Your Ref: OWPC2689
Our Ref: AB/130/13/ 16-12-2013
Please ask for:
Mrs A Gardner

Change of use and extension to create 3no. self contained apartments and 1no. maisonette. This application affects the character and appearance of Arundel Conservation Area
Arden Guest House 4 Queens Lane Arundel

1:500 Block Plan

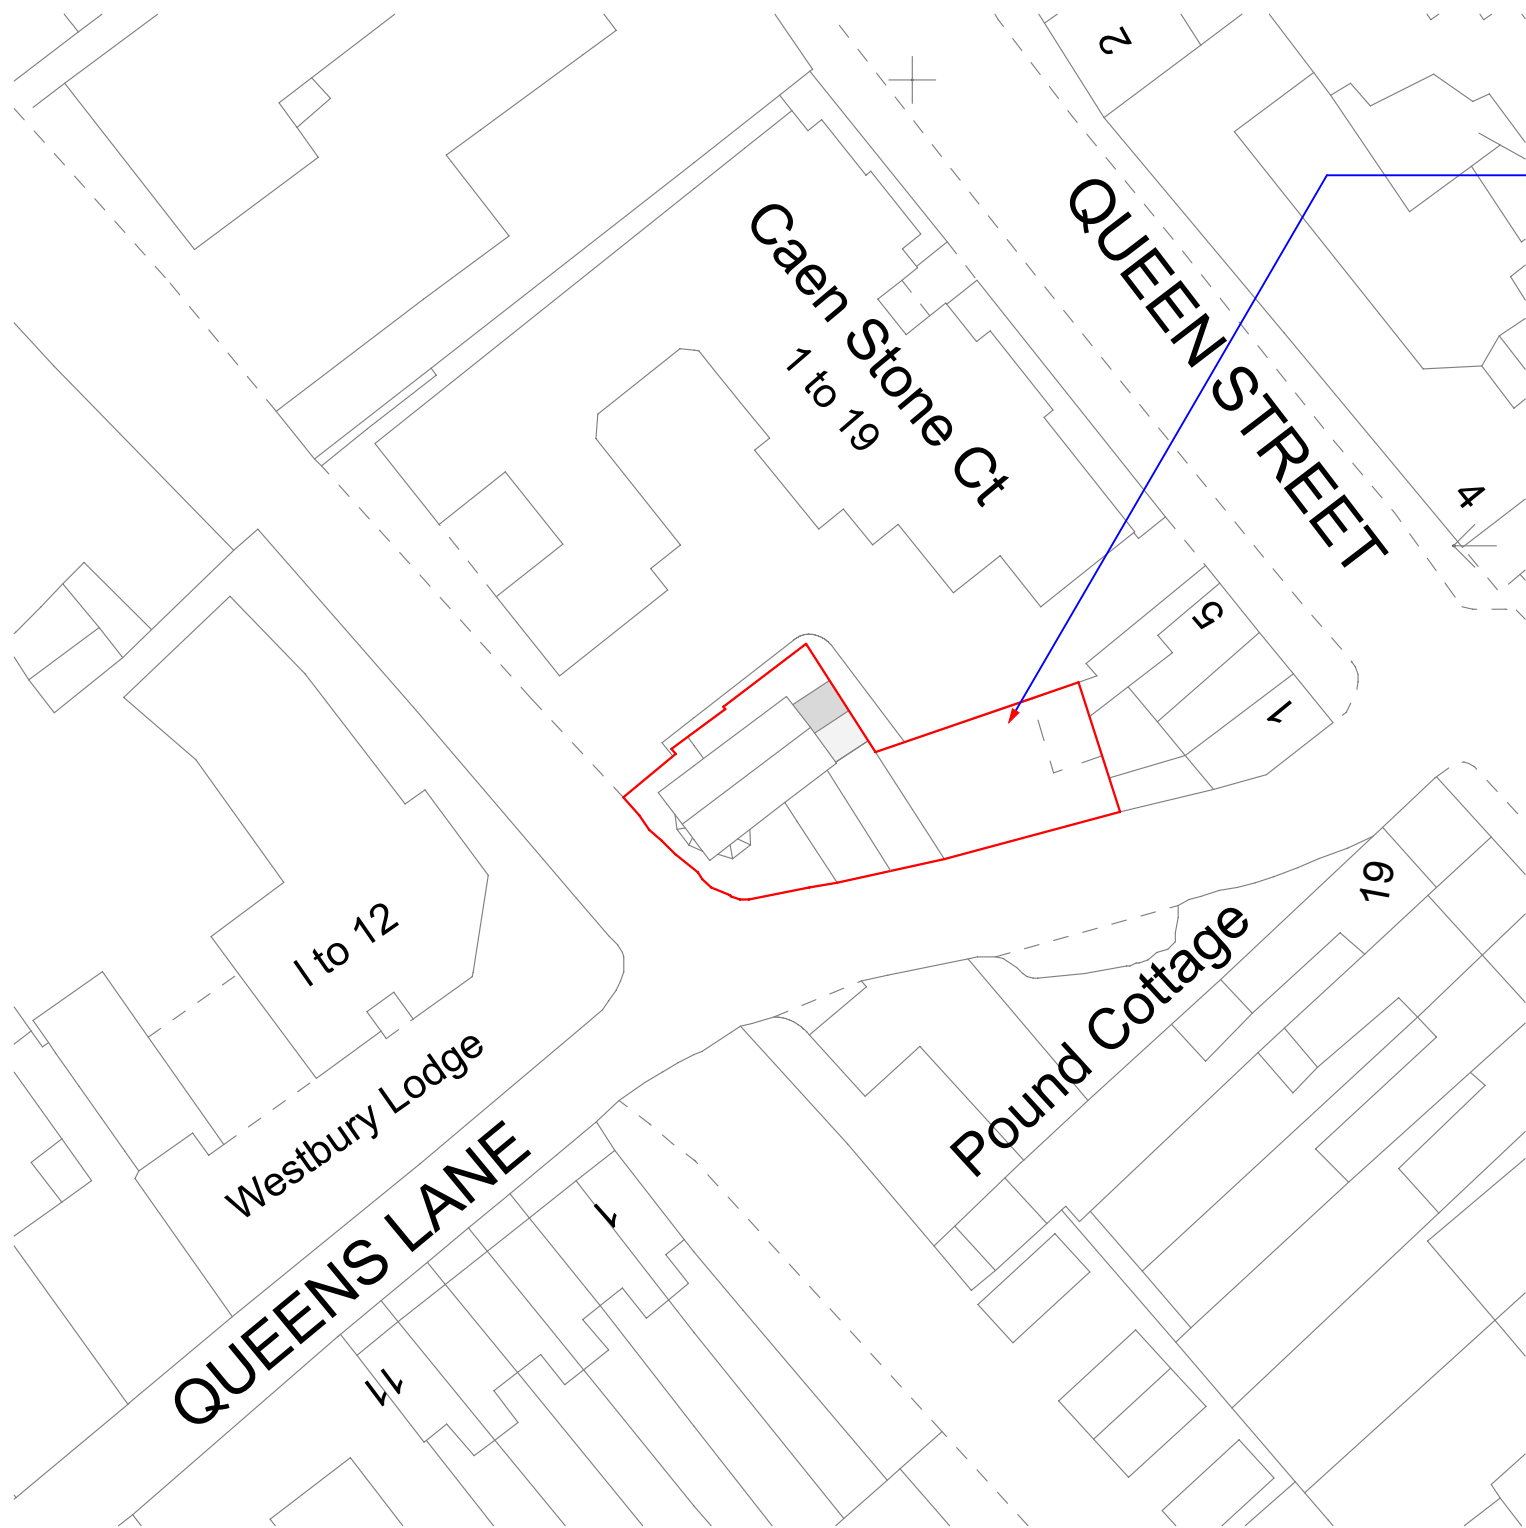
The planned parking spaces will result in more cars parked on the site and an increase in traffic onto and from Queens Lane. The current parking restrictions in Queens Lane are inadequate and need to be upgraded with additional double yellow lines and a reduction in on-street parking. This will improve road safety for vehicles and pedestrians.

Quite clearly, measures will need to be taken during any resulting development to safeguard current access facilities for residents of Caen Stone Court and their vehicles.
